11 August 2022

RE: Development Application SSD-31179510 at 2A Gregory Place (Build-to-rent) Harris Park

6.2.7 Clay Cliff Creek Stormwater Channel Walk

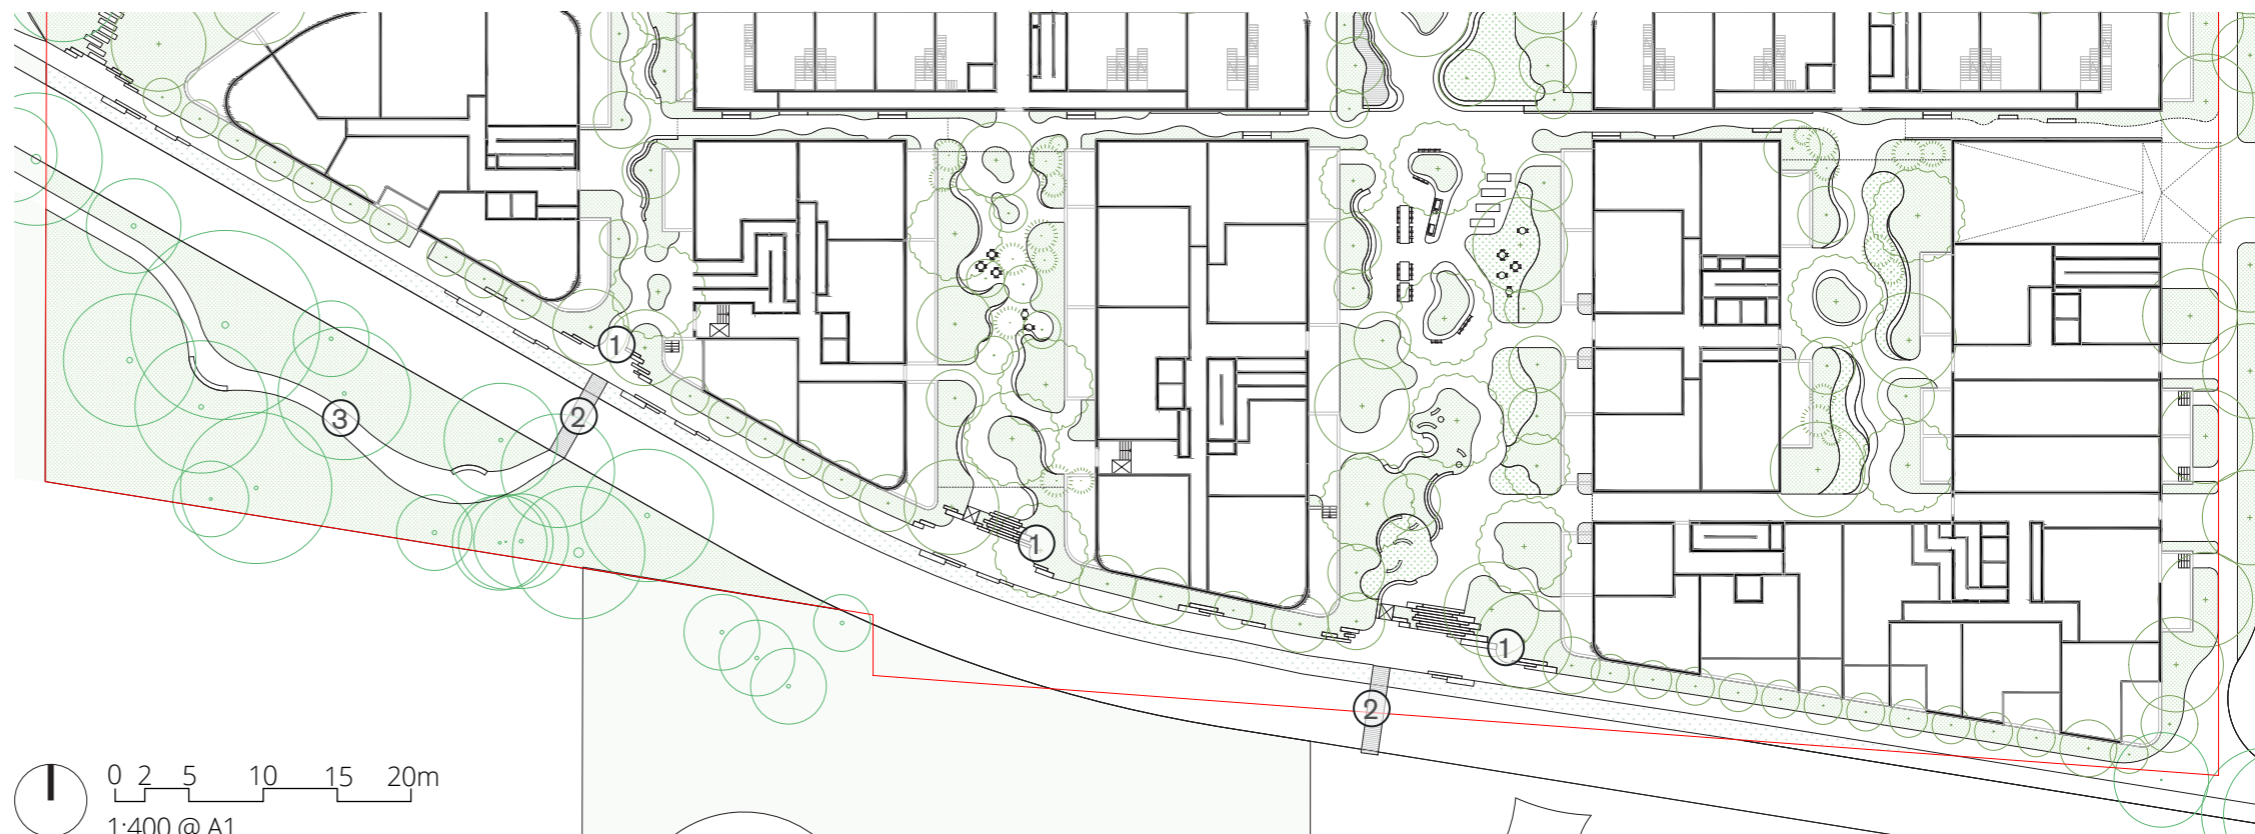
- No buildings or permanent structures are to be proposed over the stormwater channel or within **1m** from the outside wall of the channel or within the Sydney Water easement whichever is larger. Permanent structures include (but are not limited to) basement car park, hanging balcony, roof eaves, hanging stairs, stormwater pits, stormwater pipes, elevated driveway, basement access or similar structures. This clearance requirement would apply with unlimited depth and height.
- **The applicant is required to submit the elevation drawings with the stormwater channel/ pipe, to ensure that the proposed buildings and permanent structures are 1m away from the outside face of the stormwater channel and away from the Sydney Water easement.**

- The proponent needs to ensure that the proposed Clay Cliff Creek walk is located at least 1m away from the outside face of the Clay Cliff Creek wall.
